PLANNING BOARD REPORT

Commercial Development including gas station and convenience store with ATM

2282 Congress Street

Project ID #2013-086

DeLUCA-HOFFMAN ASSOCIATES, INC.
778 MAIN STREET, SUITE 8
SOUTH PORTLAND, ME 04106
207.775.1121
WWW.DELOCAHOFFMAN.COM
DRAWN: CMW | DATE: MAR. 2013
DESIGNED: SRB | SCALE: 1" = 30'
CHECKED: SRB | JOB NO. 3118
FILE NAME: 3118-SP
SHEET: C-2.0

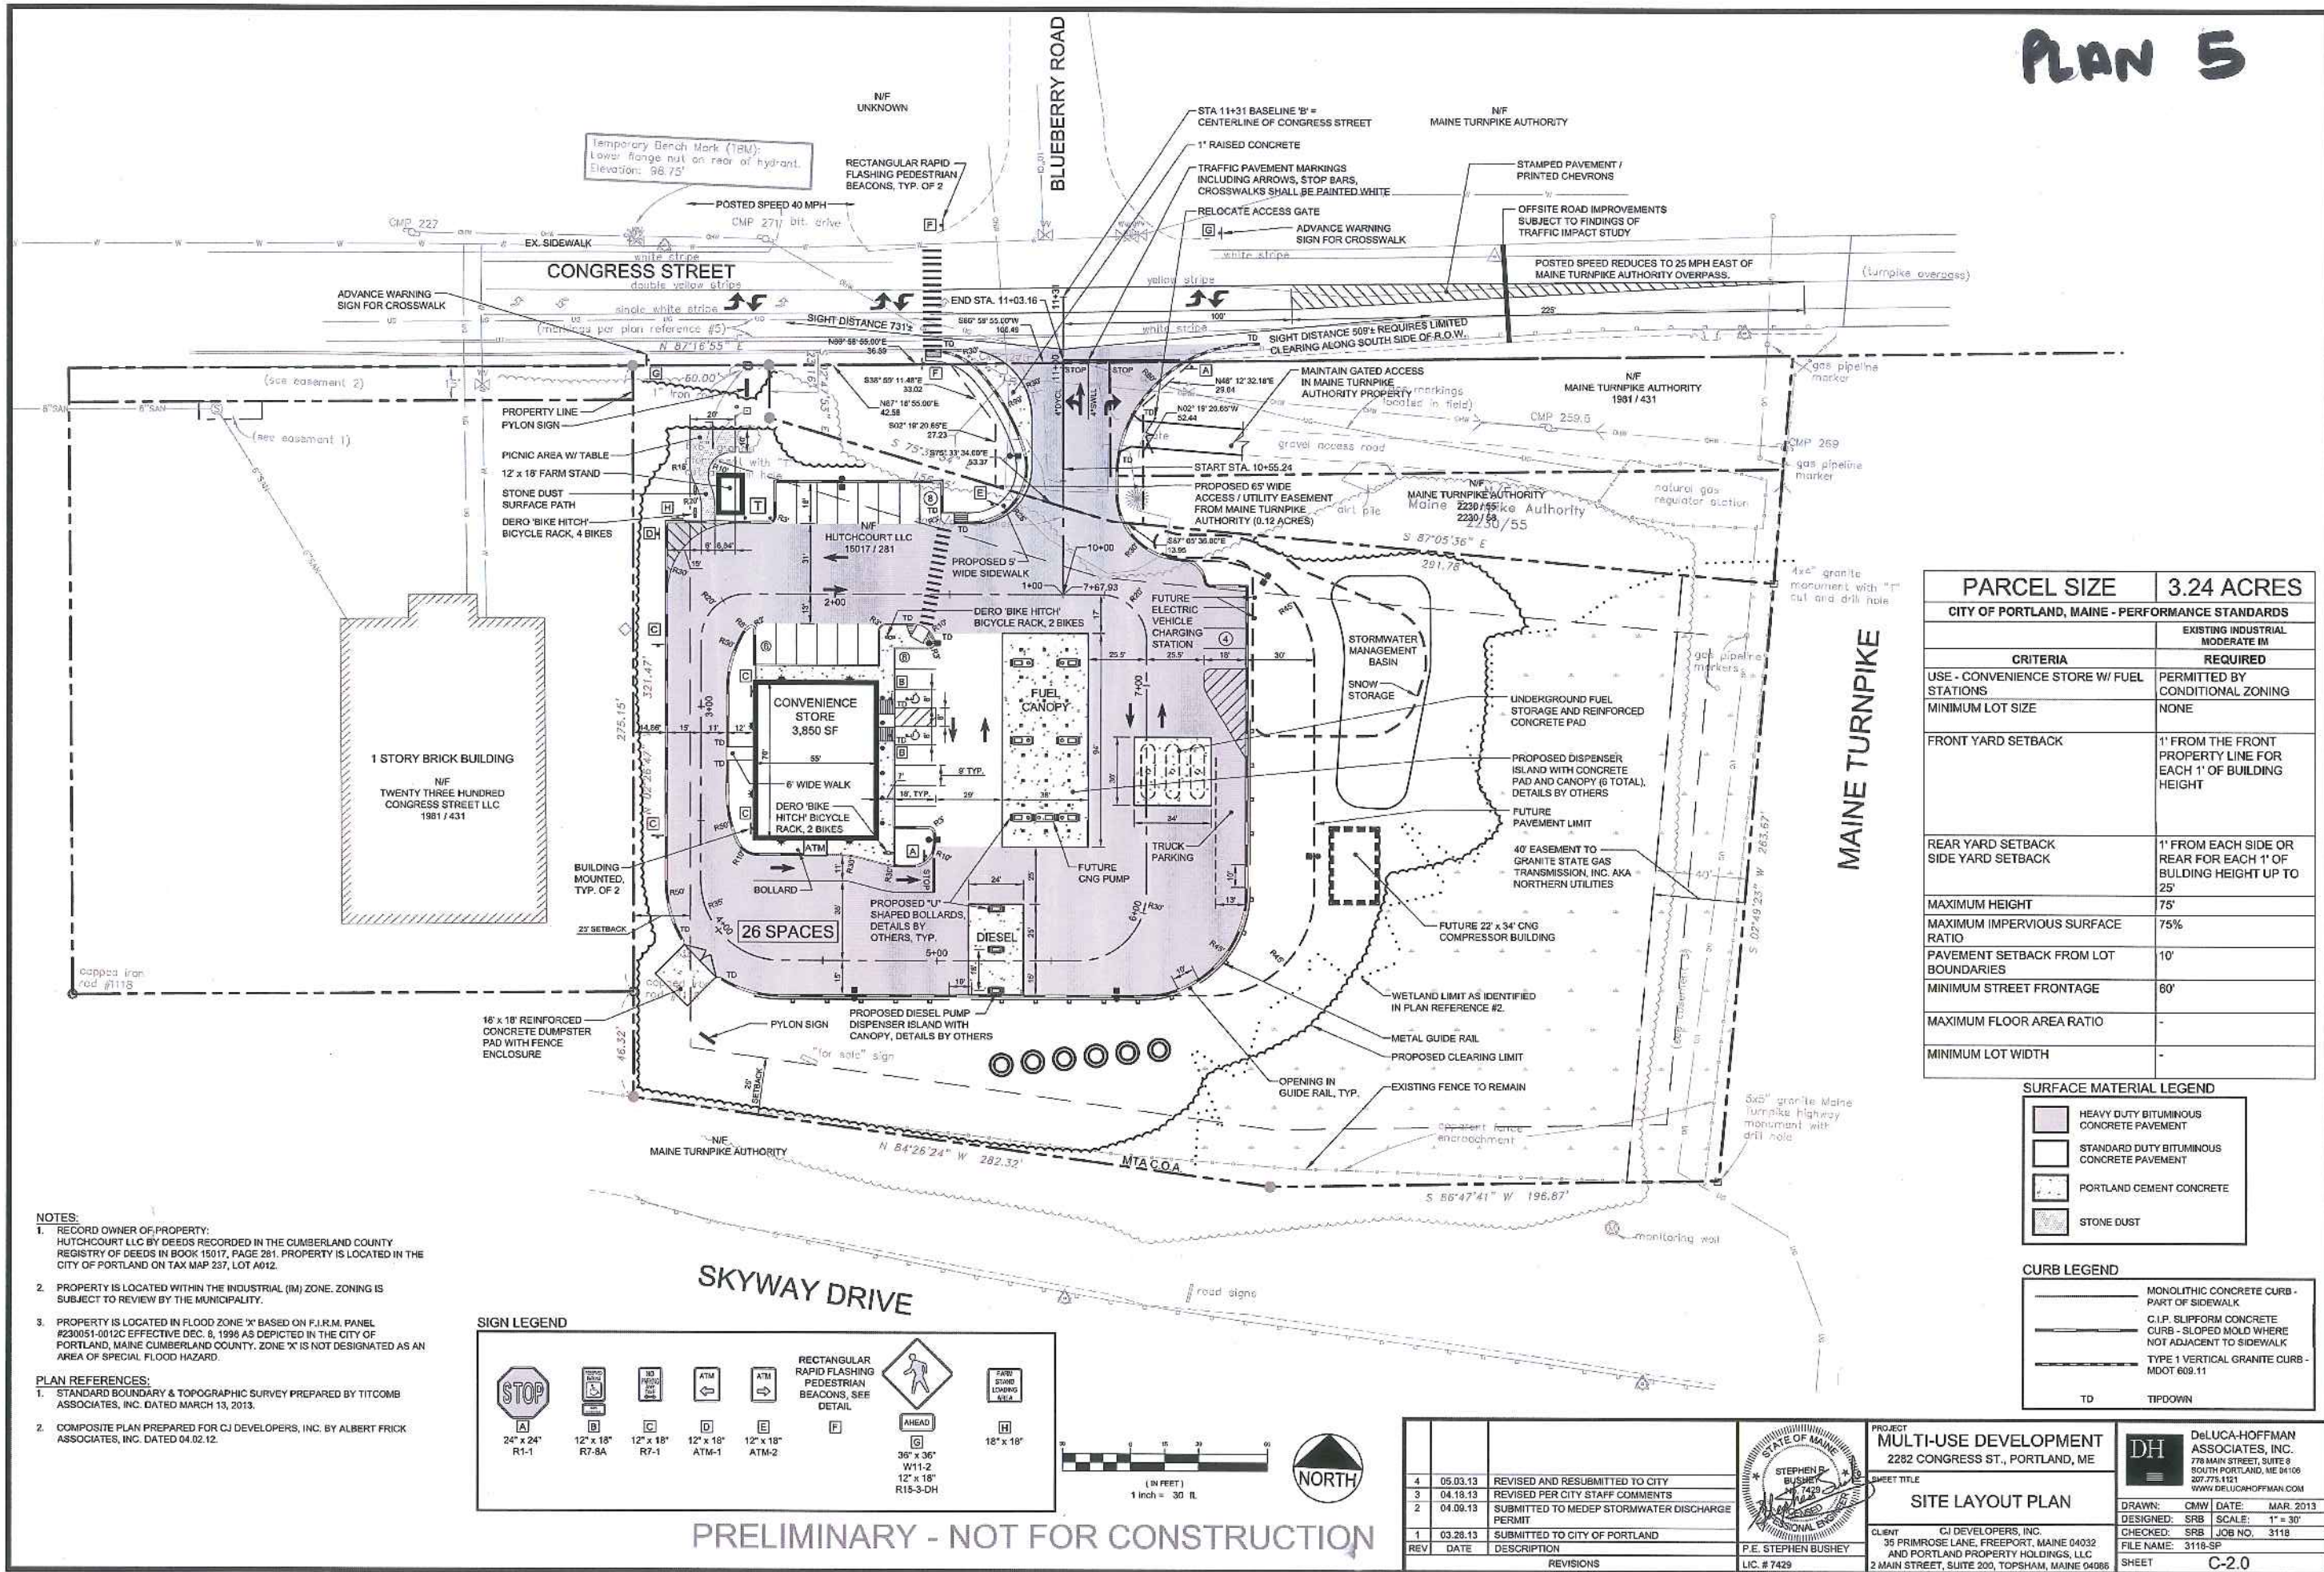
The site plan (Plan 5) shows 12 gas fueling stations under the canopy plus 2 diesel fuel dispensers at a separate island at the rear of the site. A future Compressed Natural Gas pump is shown with the gas pumps under the canopy and a future electric vehicle charging station (4 bays) is included on the east side of the paved area.

The site access on Congress Street allows for left turns from Congress Street into the site and Plan 5 (Site Layout) shows the associated new pavement marking and signs. Potential condition *iv* incorporates the comments from Mr Errico:

The applicant has indicated the snow storage areas on the final site plan, see Plan 5, which is satisfactory.

The applicant has developed an improvement plan for Congress Street such that left-turn accommodations are provided. I support the general concept of the plan provided in the application. Final design plans shall be submitted to the City for review and approval (It should be noted that adjustments to the design may be required during this review process). (Attachment 7)

PLAN 6

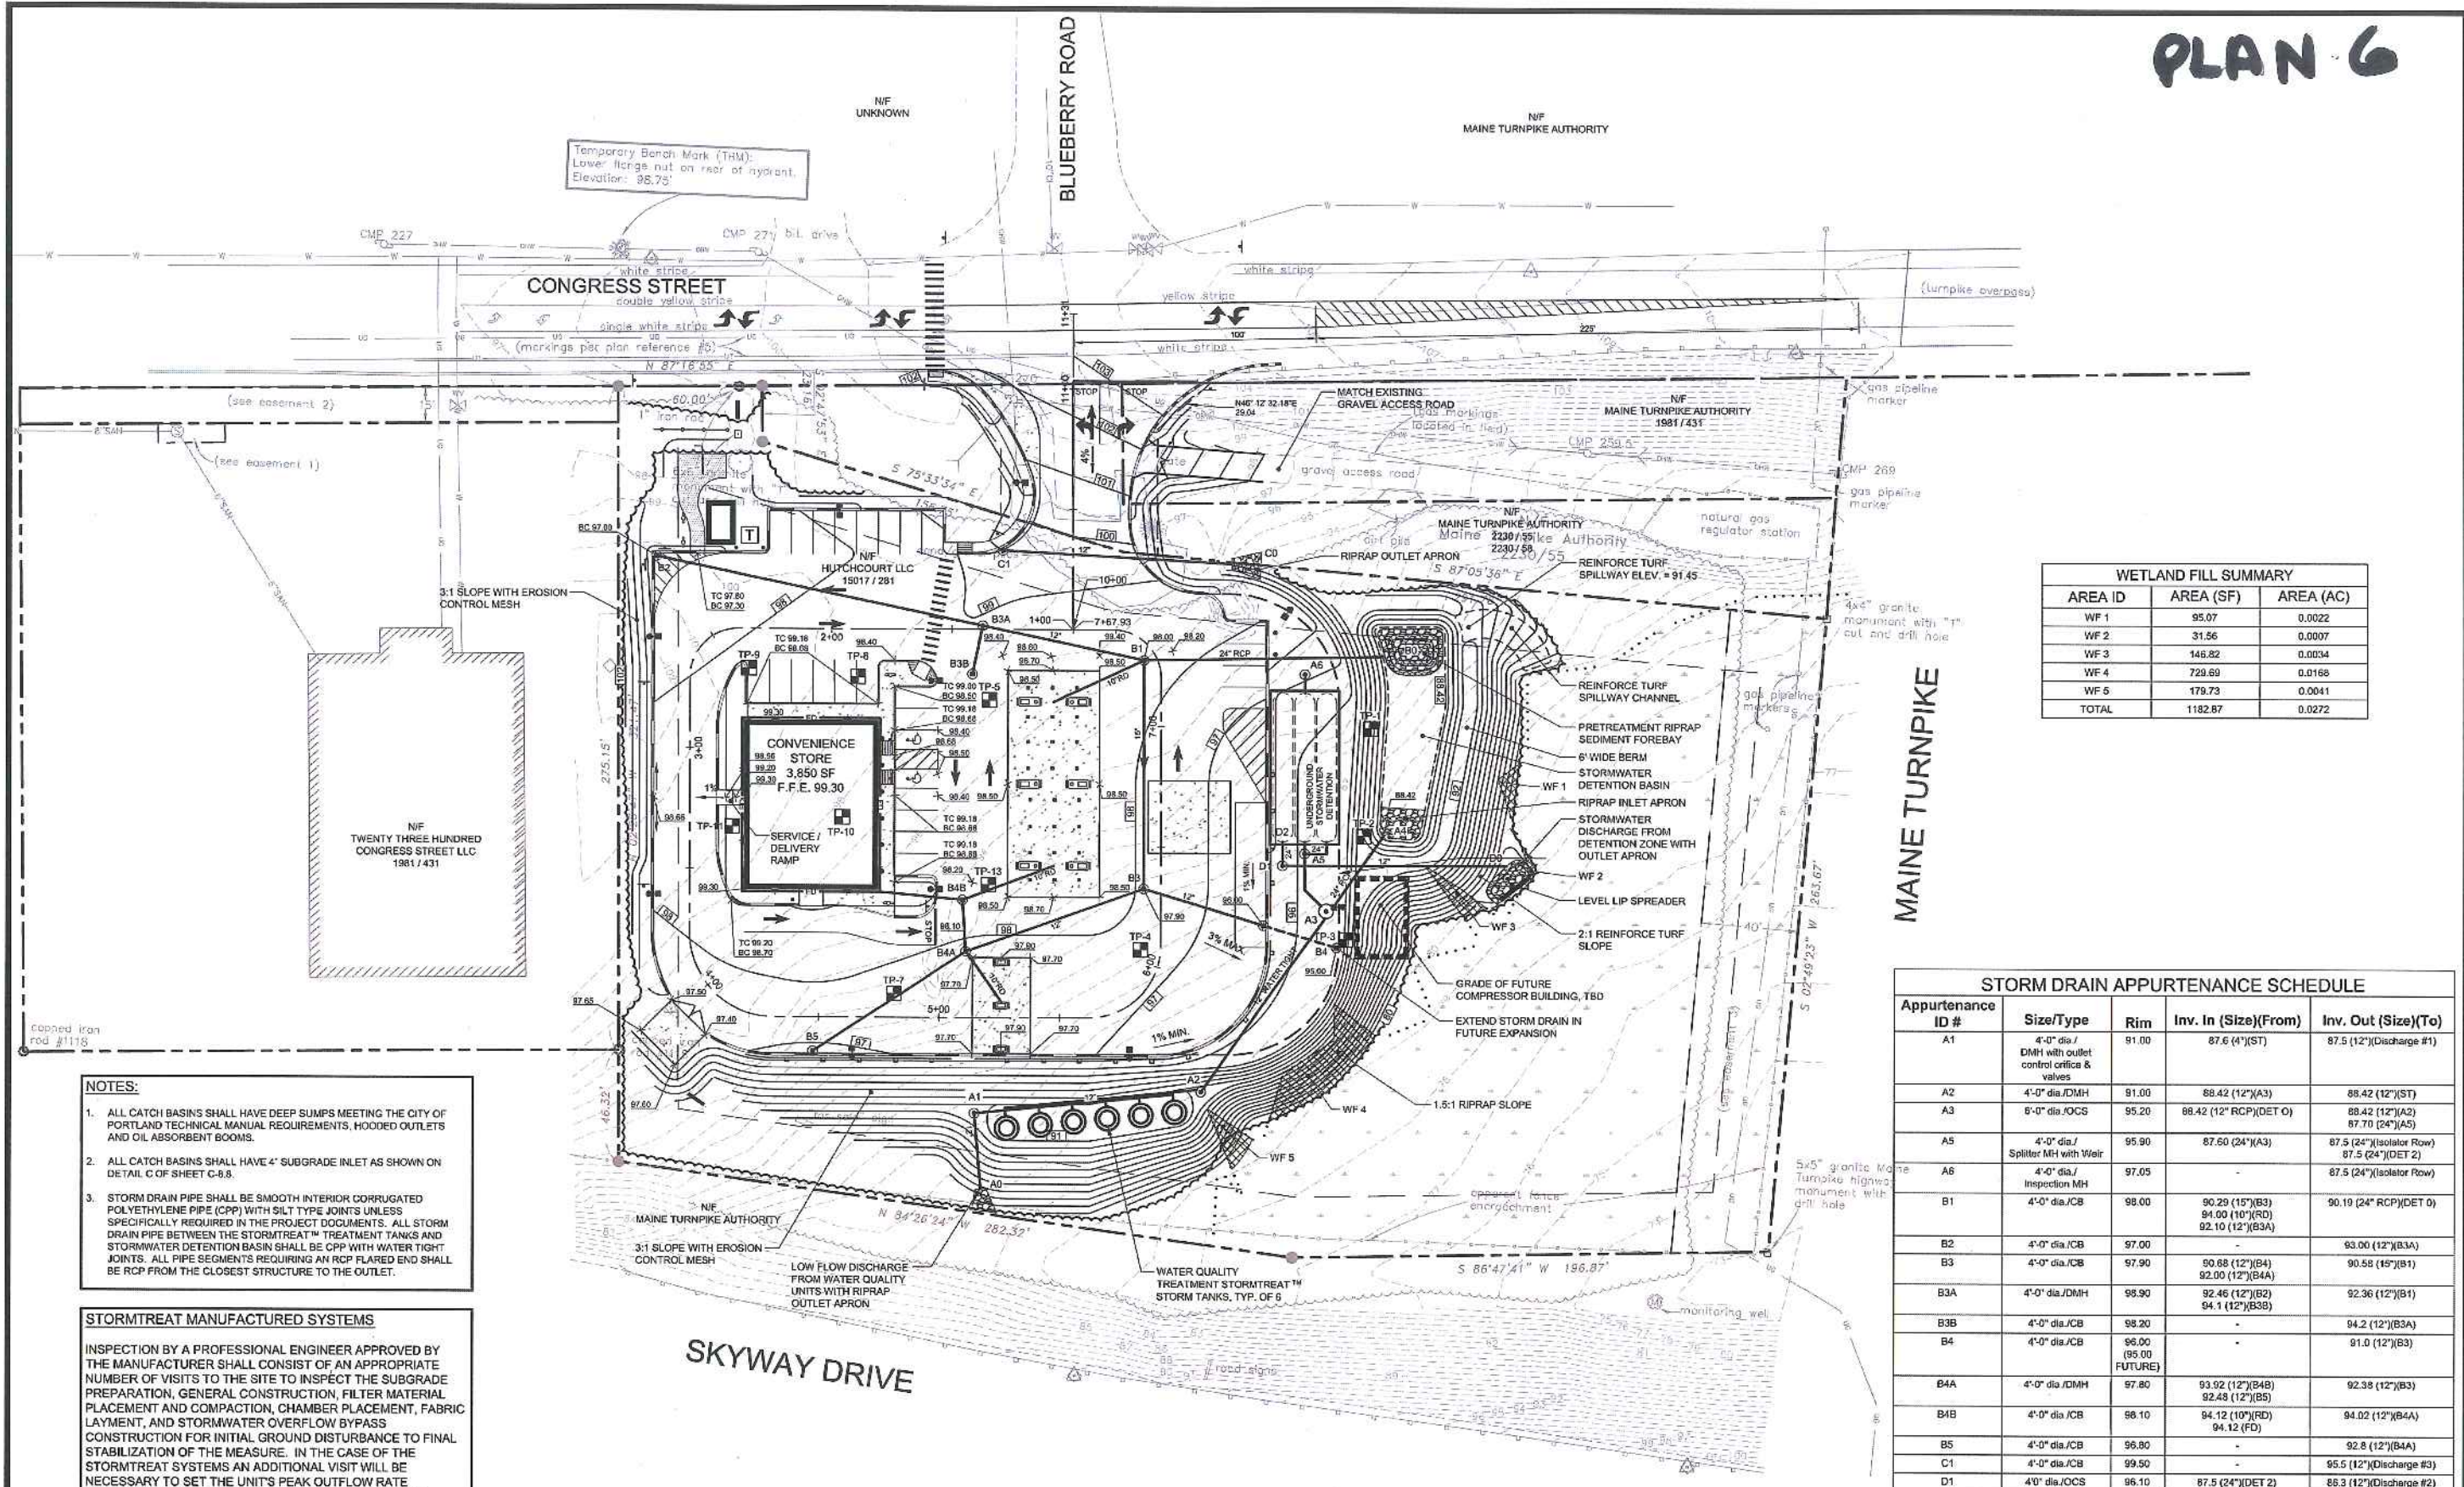
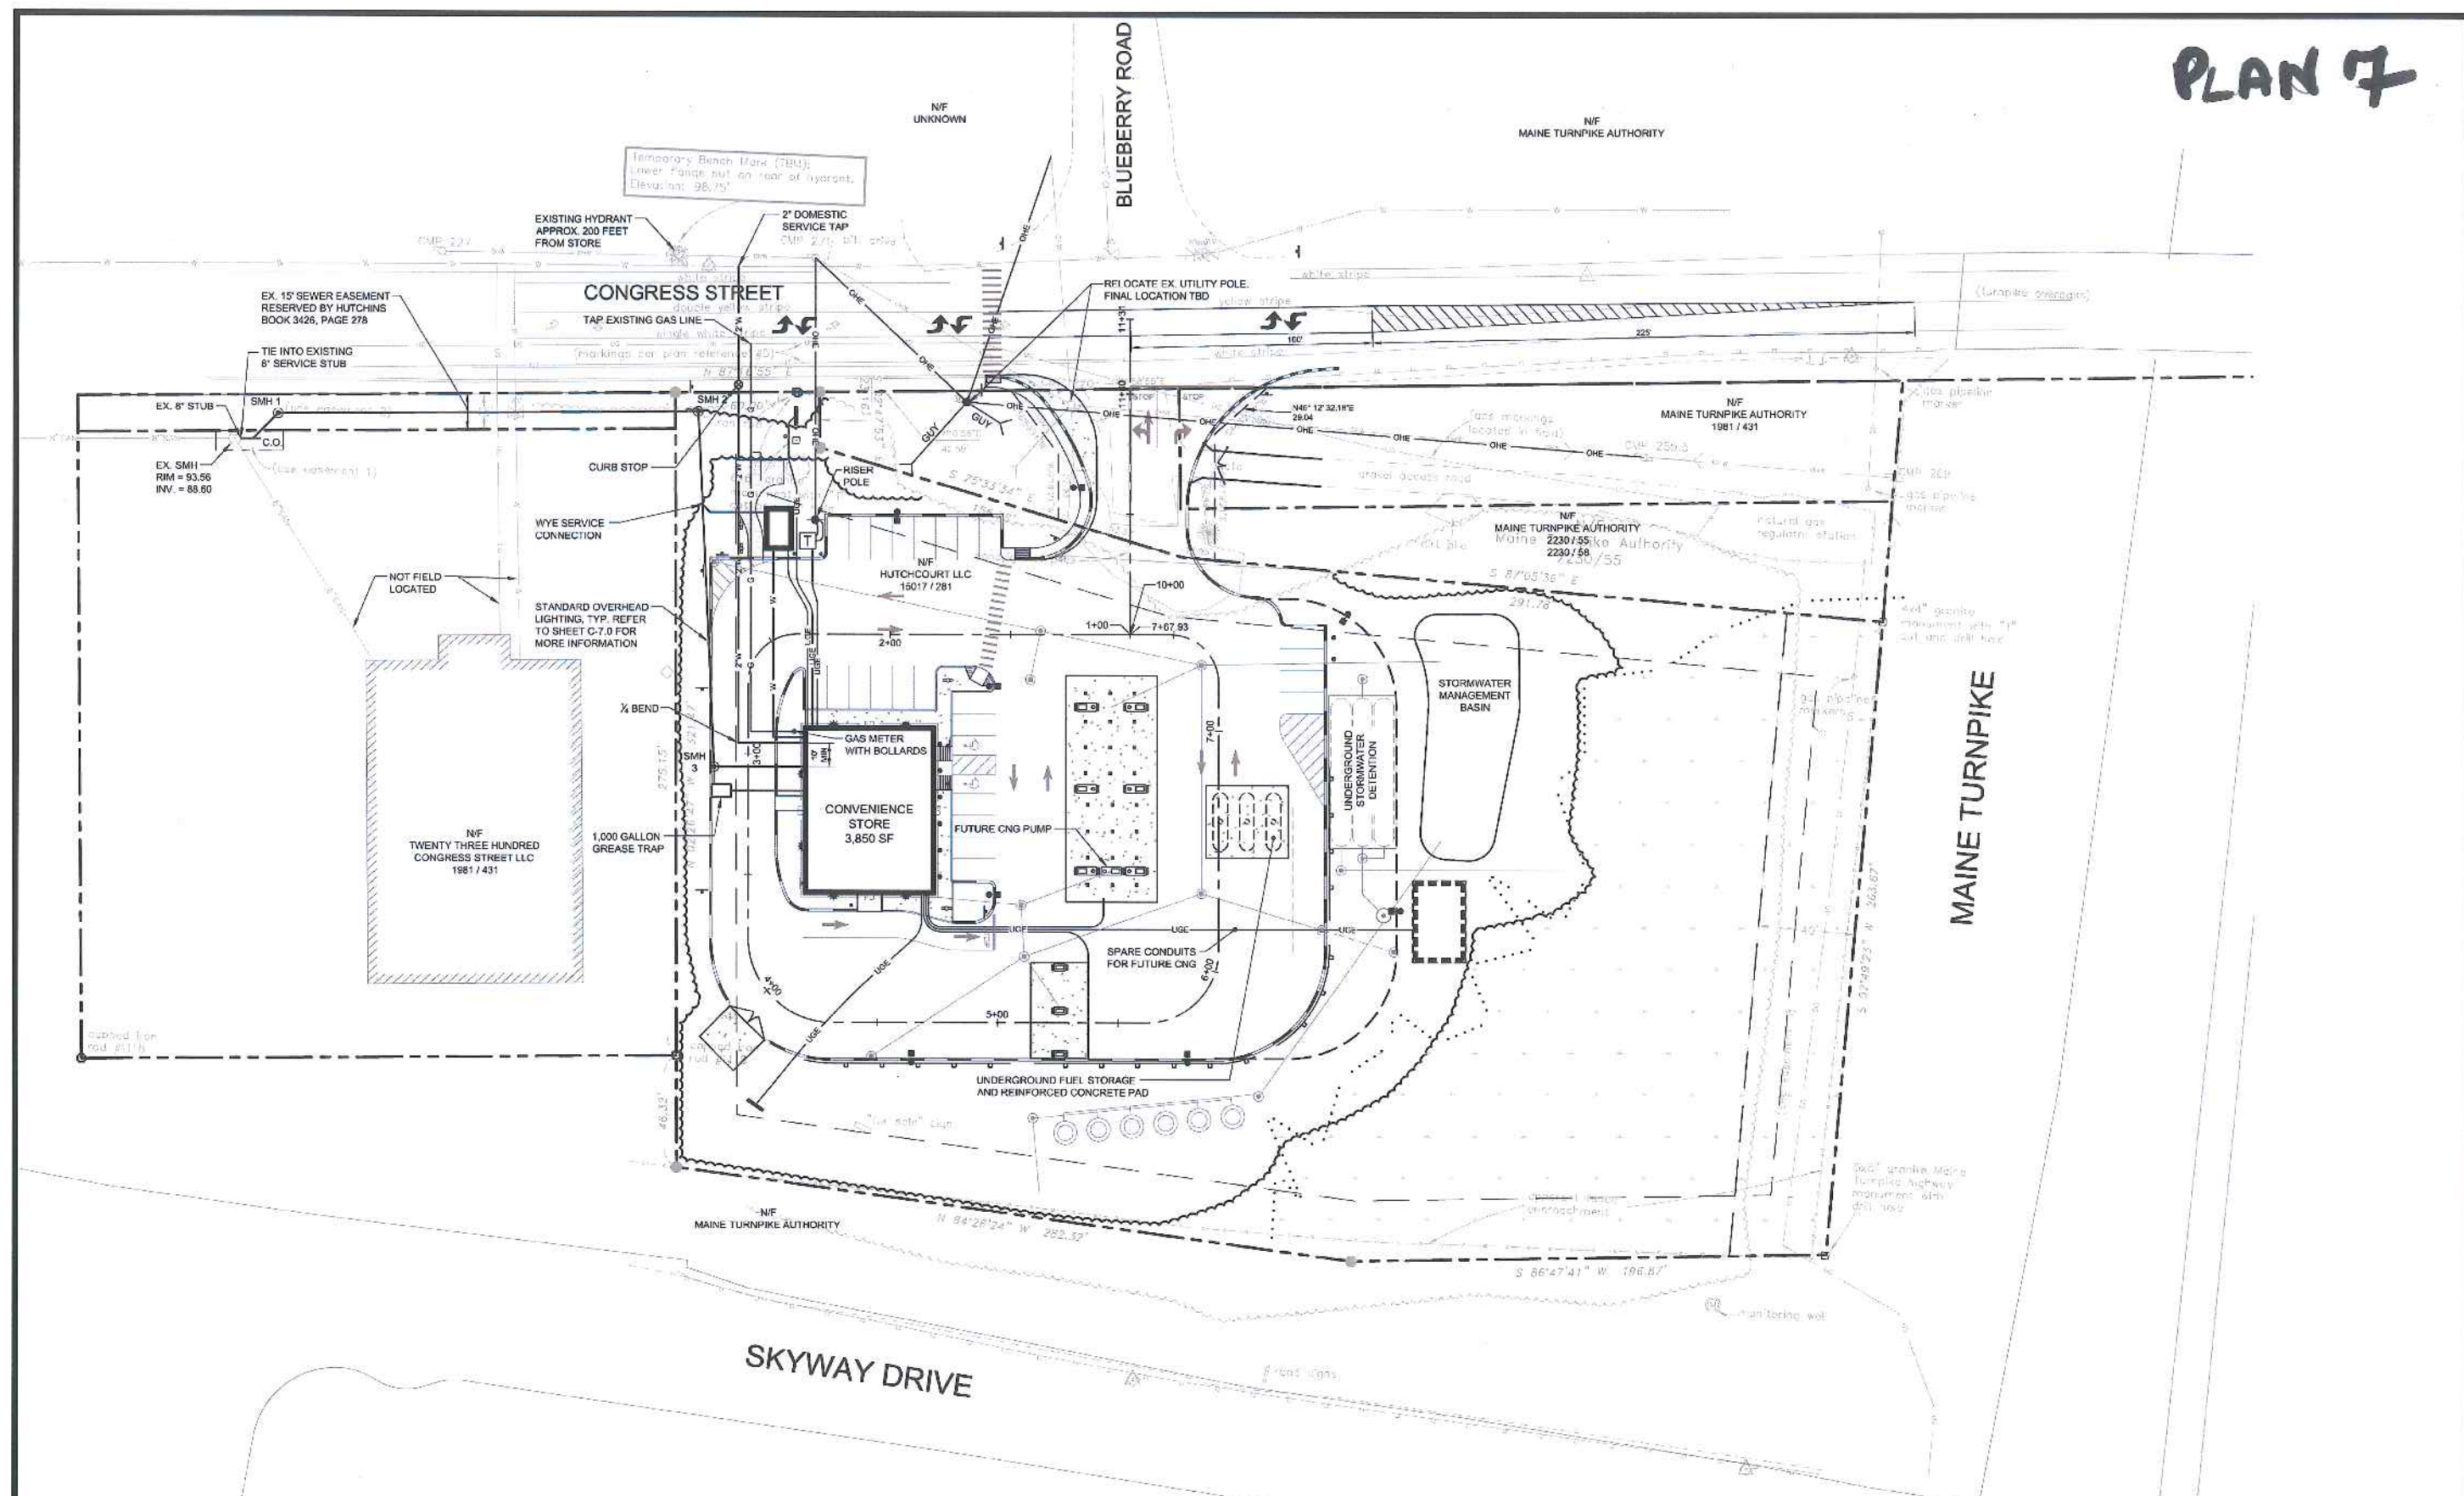
[Plan 6](#) (Grading and Drainage) shows the stormwater system which is described in [Attachment G.1](#); details are included in [Plans 9.1, 9.2 & 9.3](#). The system comprises a stormwater detention basin on the east side of the site and an underground treatment system (“Stormtreats”) on the south side.
